Application no: H15/0638/00

Description: Proposed dwelling and garage

Location: Land at Main Road
Quadring

TOWN AND COUNTRY PLANNING ACT 1990
NOTICE OF ACCEPTANCE OF AMENDMENT

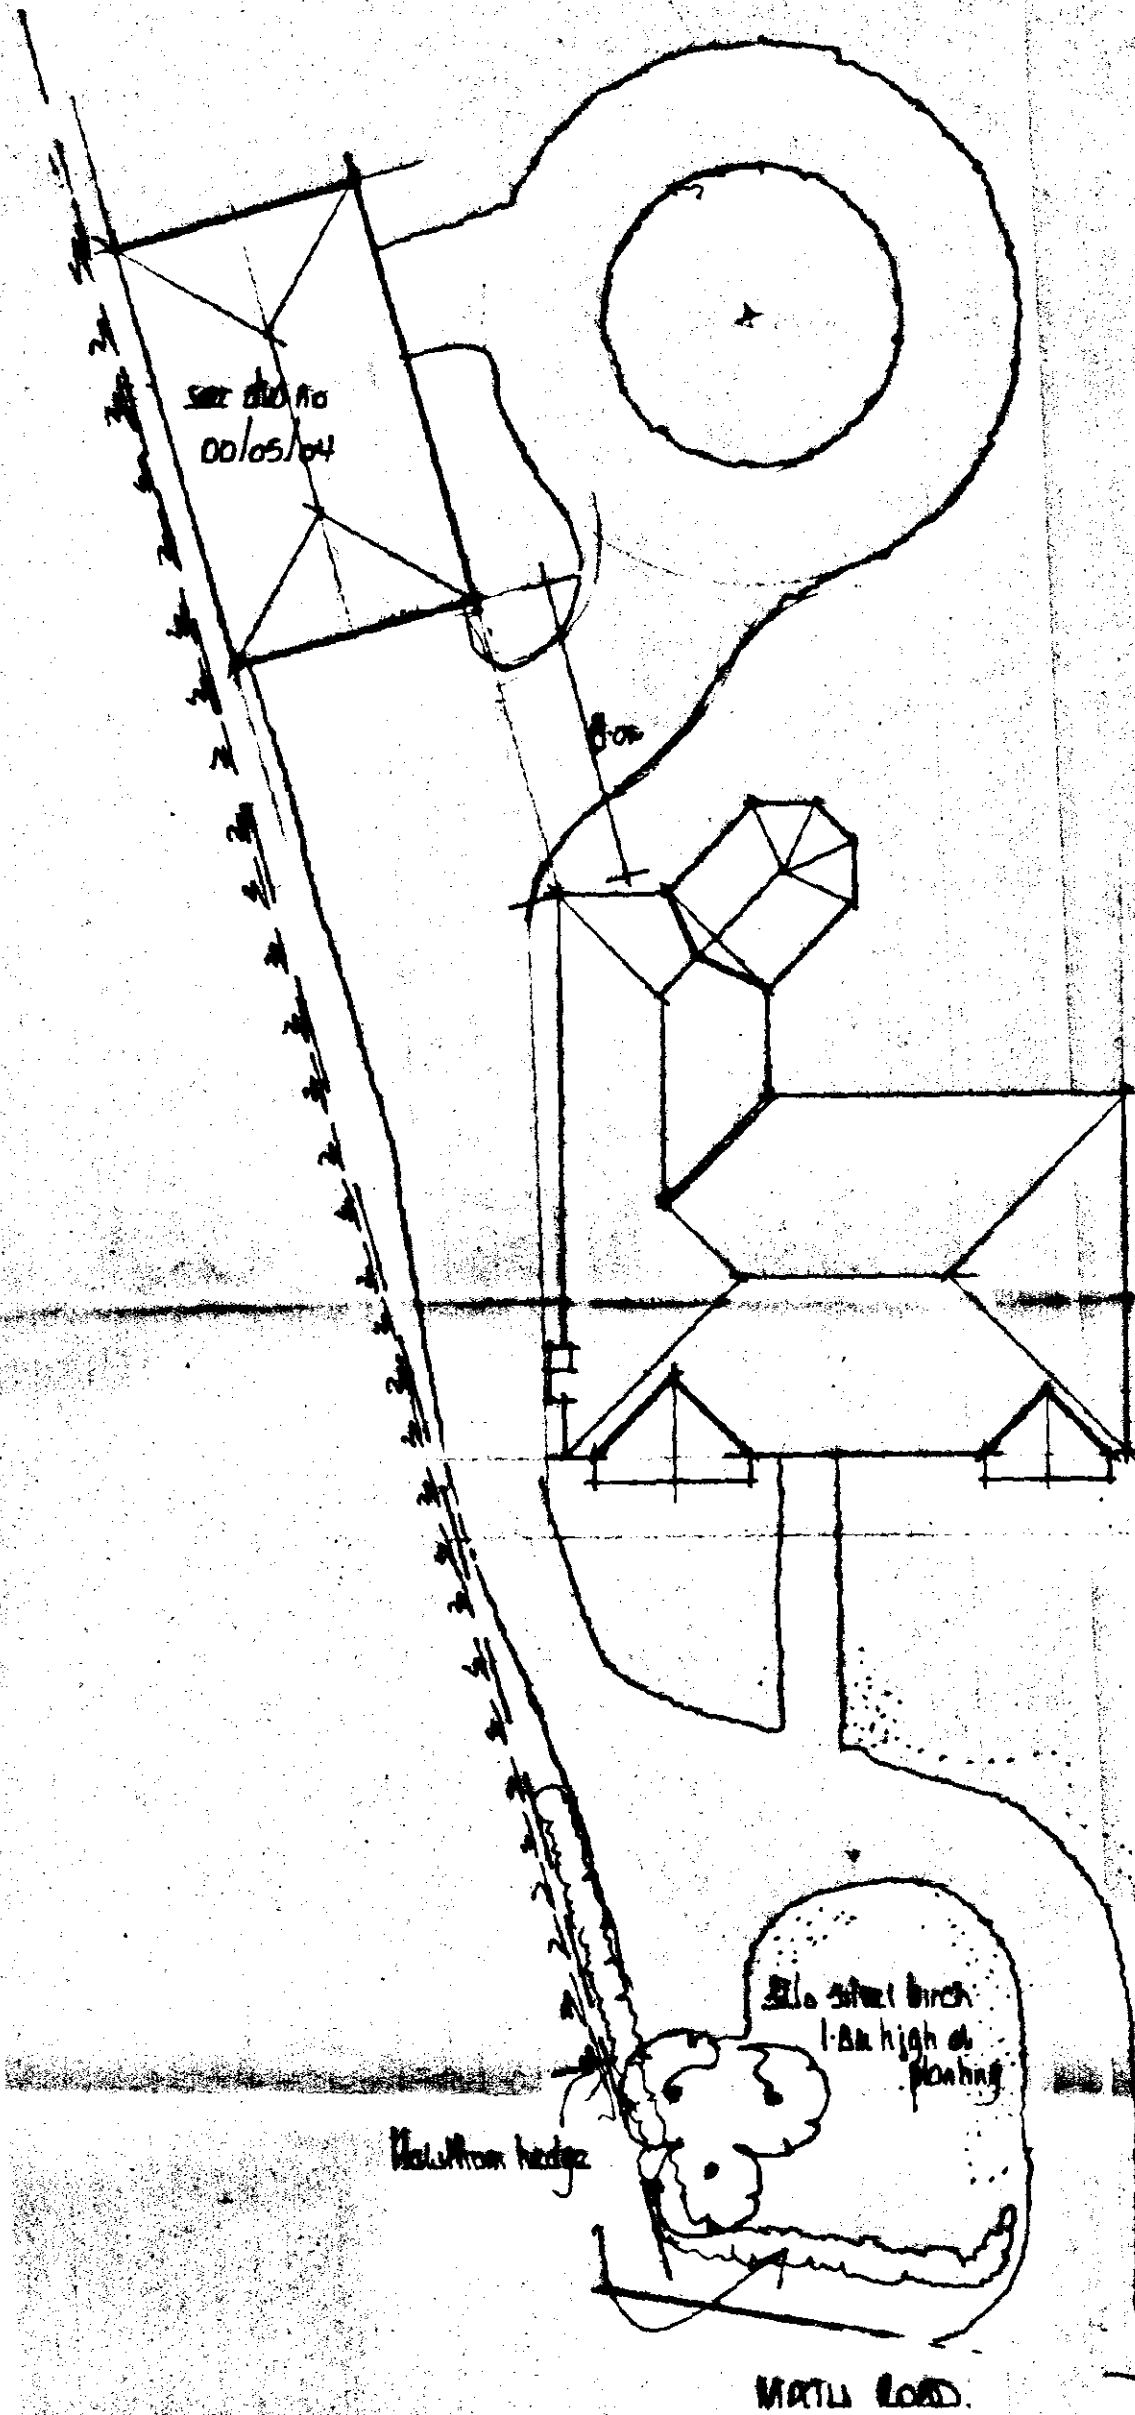
Amendment: Bungalow sited 2 metres further back from highway
dwg no. 00/05/05

BUNGALOW SITED 2-0M FURTHER
BACK FROM THE HIGHWAY

The amended details submitted in respect of the above proposal have now been considered and there are no objections to the amendment being implemented to the extent described above.

*PJU visited site + agreed relocate with neighbour.
This plan conforms with the agreed position.*
